NSIP Reference Name / Code: EN010120

Title: Natural England's comments in respect of Drax Bioenergy with Carbon Capture and Storage Project, promoted by Drax Power Limited

Natural England's Relevant Representations Version 1.1.

PROJECT:	DRAX BECCS DCO				
TITLE:	FIGURE 1 LANDSCAPE AND BIODIVERSITY MITIGATION PLAN

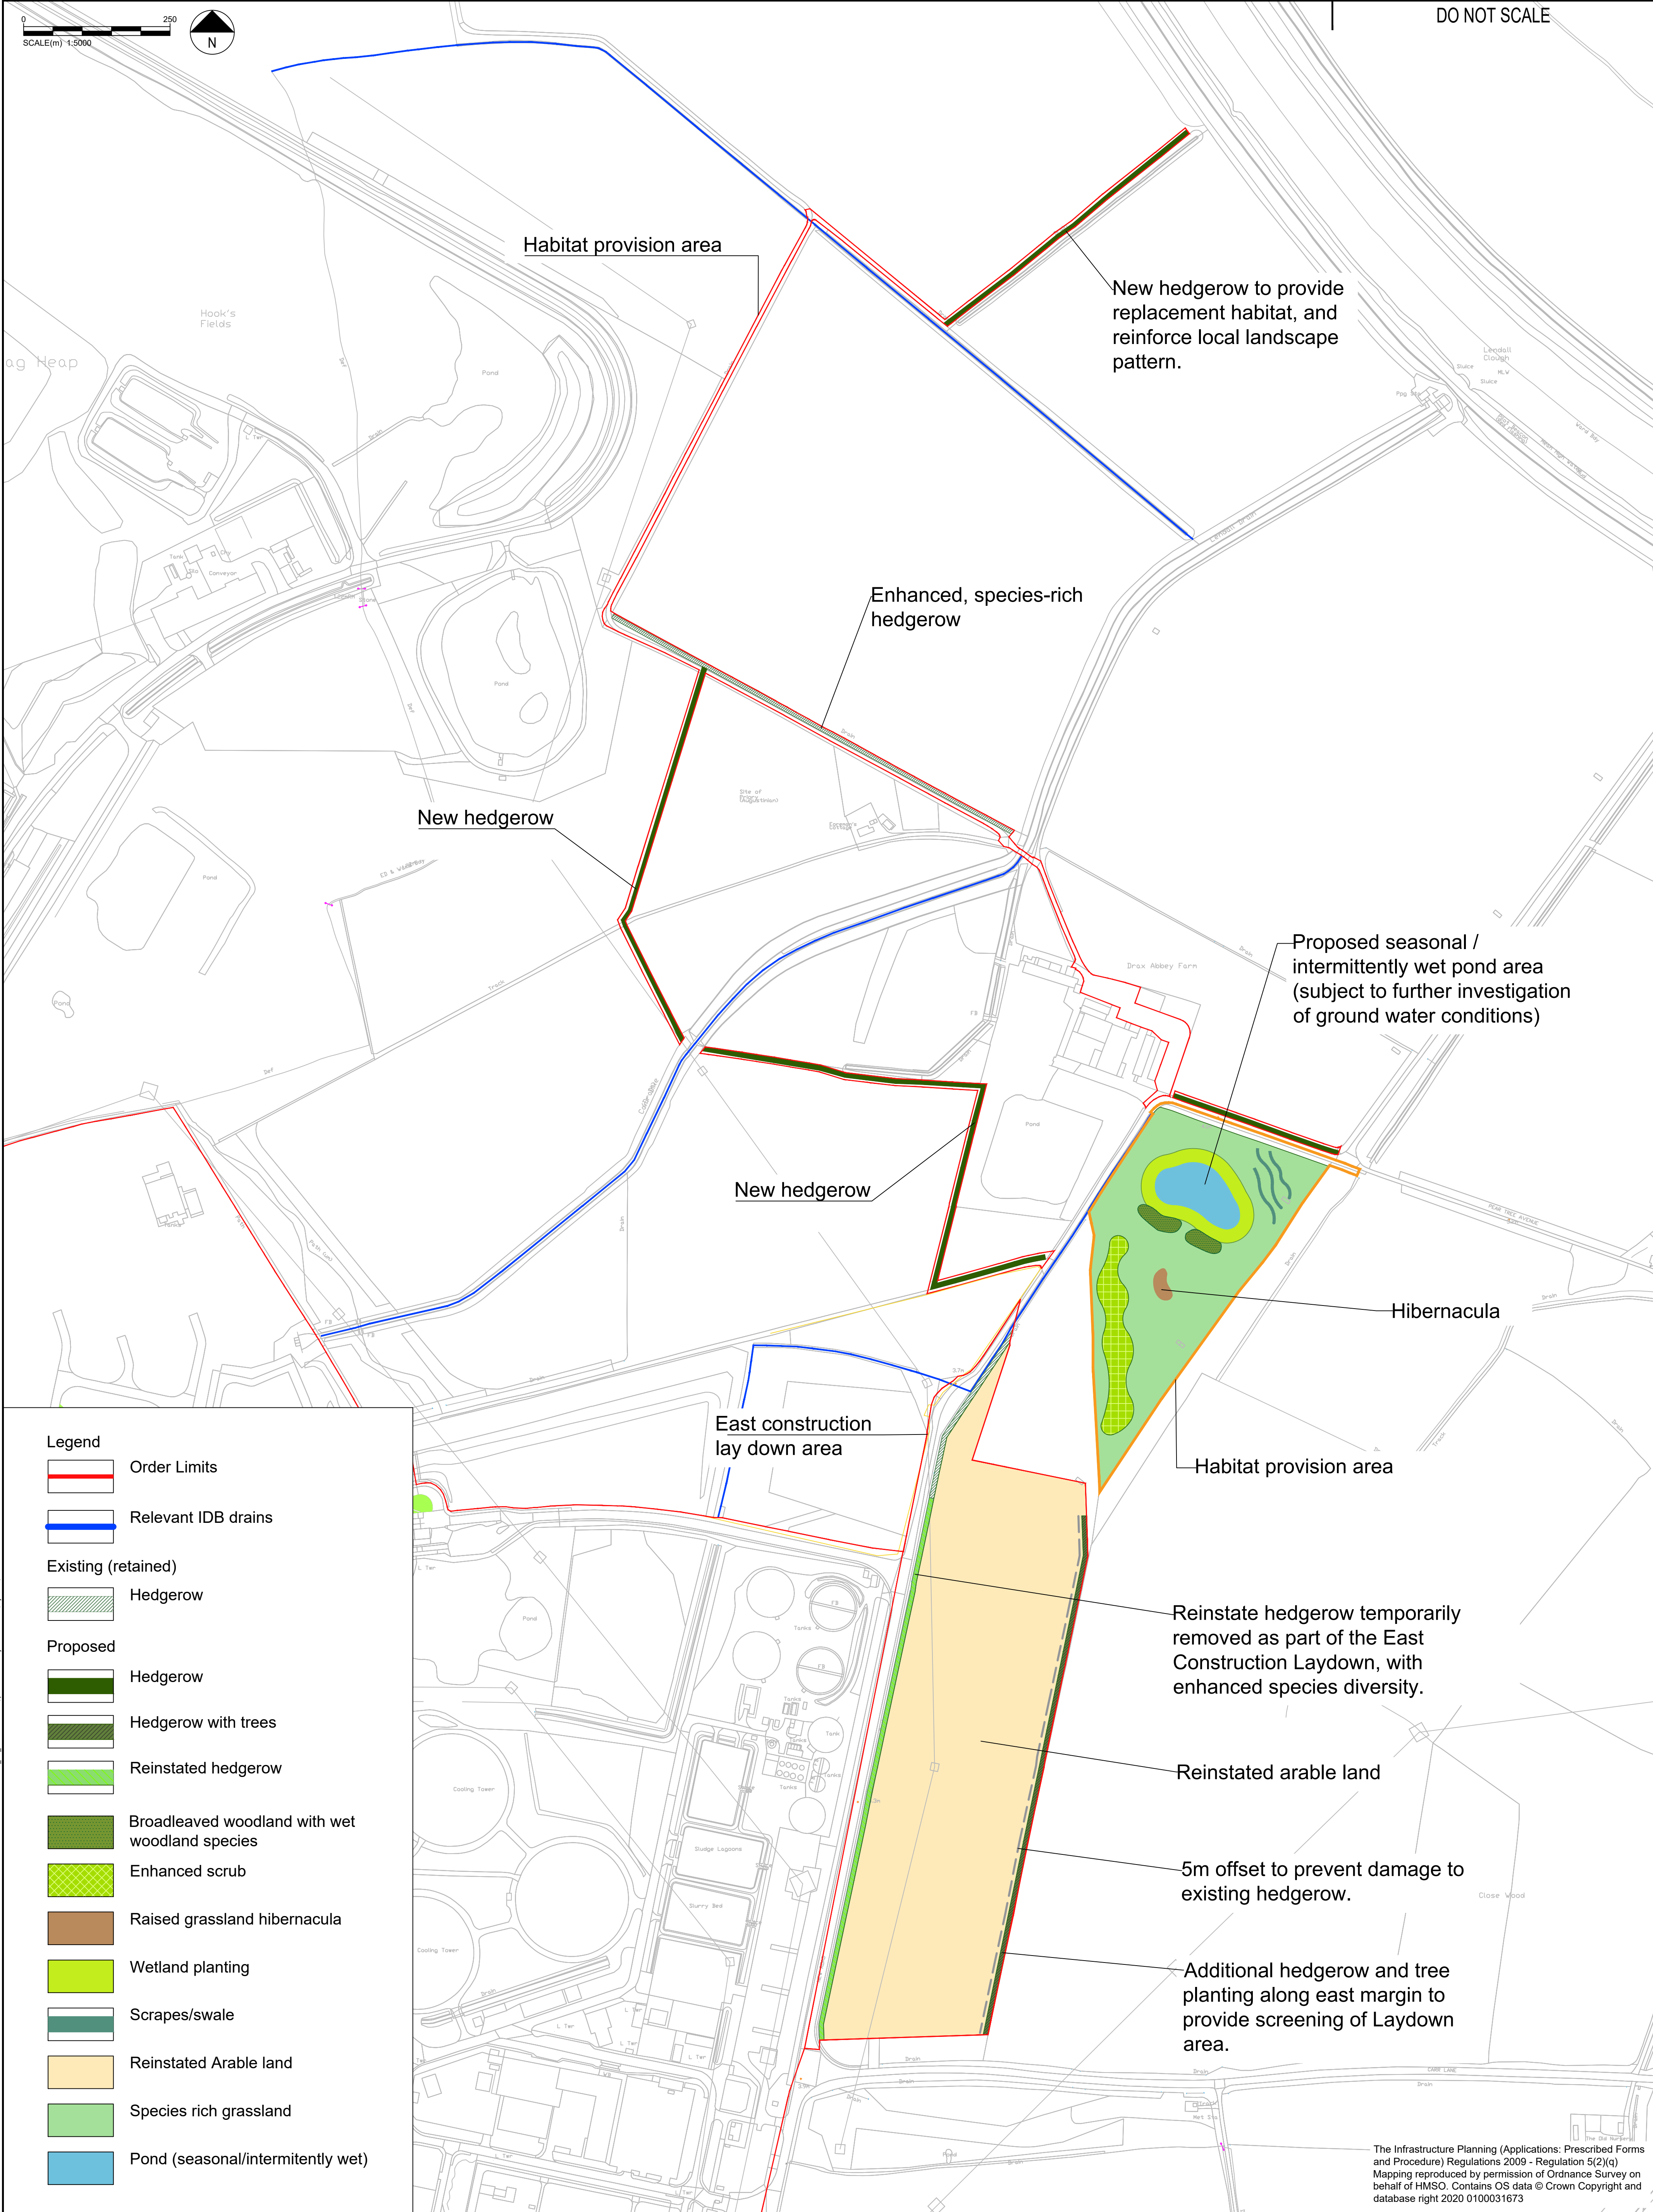
2.5.2.3. Additional information should be provided regarding sustainable soil management in the Soil Handling Management Plan. Inappropriate soil handling is currently proposed for the Habitat Provision Area ('amber').

<p>(Outline Landscape and Biodiversity Strategy).</p> <p>The Outline Landscape and Biodiversity Strategy (6.6.1) currently suggests topsoil stripping for the habitat provision areas.</p> <p>Paragraphs 3.3.16 and 3.3.34 state that to prepare the Habitat Provision Area to the north of the East Construction Laydown Area and the Off-Site Habitat Provision Area, the topsoil will either be removed or topsoil inversion will be undertaken. This would be disturbance or potential soil loss which is not currently considered in the EIA (Chapter 11). Topsoil stripping will result in a surplus of the finite soil resource.</p> <p>Natural England advises that the habitat creation and seed mixes are tailored to the soil resource present on site, using data presented in Appendix 11.2, avoiding the need for soil stripping or inversion.</p>	<ul style="list-style-type: none"> • The SHMP should include the type and volume of each soil type to be stripped and stockpiled; the nutrient status of the anticipated surplus soil units to inform the potential suitability for biodiversity enhancement; and where required, the location of soil storage and restoration, derived from the ALC survey. • For areas of temporary development, the ALC grade determined from the soil survey should be used to inform the restoration criteria, with temporarily disturbed BMV land returned to the same quality as far as practicable to minimise potential loss. • The methods by which the applicant intends to restore affected areas to agricultural use after works including excavations and restoration has finished. • An aftercare programme which would enable a satisfactory standard of agricultural after-use to be reached, with regards to cultivating, reseeded, draining or irrigating, applying fertiliser, or cutting and grazing the site. <p>Natural England would advise that commitments are made by the applicant to safeguard soil resources, including the provision of an appropriately experienced soil specialist to advise on and supervise soil</p>

<p>handling, including identifying when soils are dry enough to be handled.</p> <p>All soil should be sustainably reused on site, either for reuse during operation or following decommissioning for restoration purposes. No soil should be disposed of. Soil inversion can damage the soil functioning and soil health and should be avoided.</p> <p>Defra has published a <u>Construction Code of Practice for the Sustainable Use of Soils on Construction Sites</u> which may be helpful when setting conditions.</p>	
--	--	--	--	--	--
